February 4, 2022

Re: Palomas Apartments
8320 Palomas Ave. NE
Traffic Circulation Layout
Architect's Stamp 12-23-2021 (D19-D032)

Based upon the information provided in your submittal received 02-02-2022, the above referenced plan cannot be approved for Building Permit until the following comments are addressed:

AS-1.0

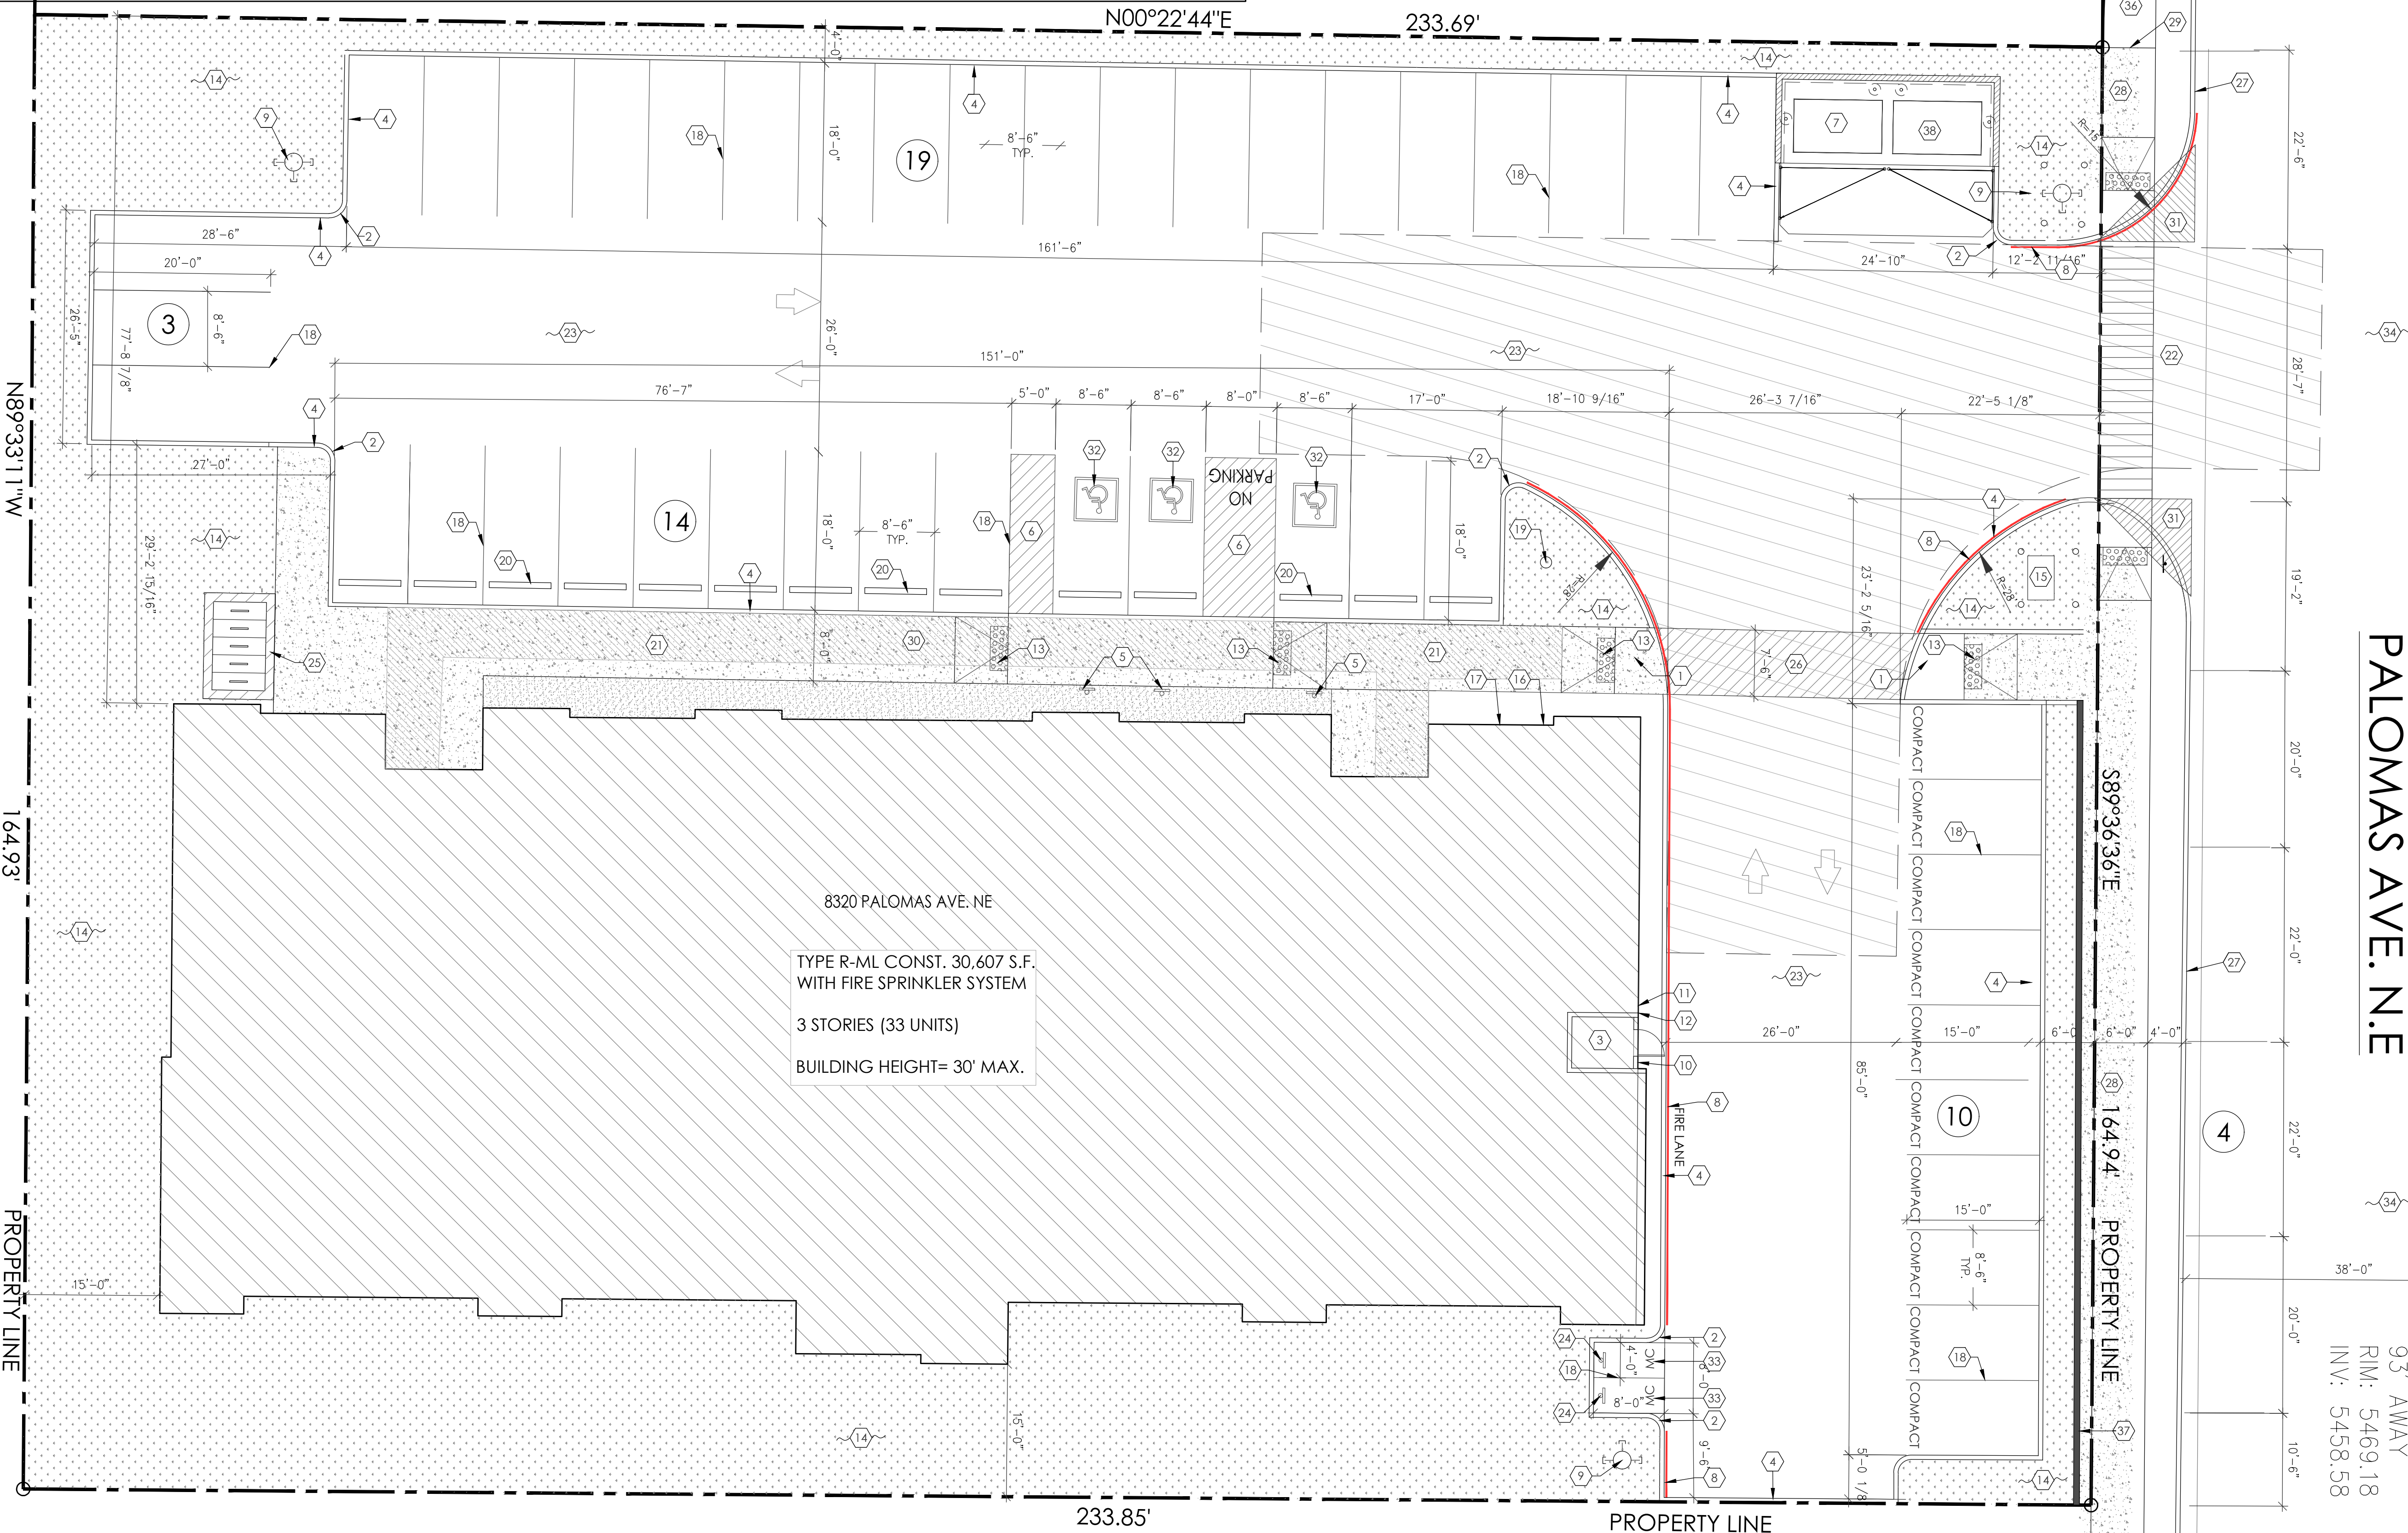
1. Please show a vicinity map showing the location of the development in relation to streets and well known landmarks.
2. Listed are the number of parking spaces required by the IDO as well as the proposed number of parking spaces including bicycle and motorcycle parking.
Coordinate/discuss with Zoning.

3. **Keyed Note 1: You will need to reference A10/AS-2.0 instead of A8 for proposed ramps adjacent to drive aisle.**
4. **Keyed Note 28:**
 - Sidewalk width will need to be provided.

- A 5:1 taper from sidewalk edge to ground elevation needs to be provided (If applicable).
5. **Keyed Note 29:** Explain why are you using COA std Dwg 2432?

6. A sidewalk easement will be needed for sidewalk located outside of public ROW
7. Motorcycle parking spaces: shall be designated by its own conspicuously posted upright sign, either free-standing or wall mounted per the zoning code. **Provide sign face detail.**

8. Per DPM, a 6 ft. wide ADA accessible pedestrian pathway is required from the ADA parking stall access aisles to the building entrances. Please clearly show this pathway and provide details.
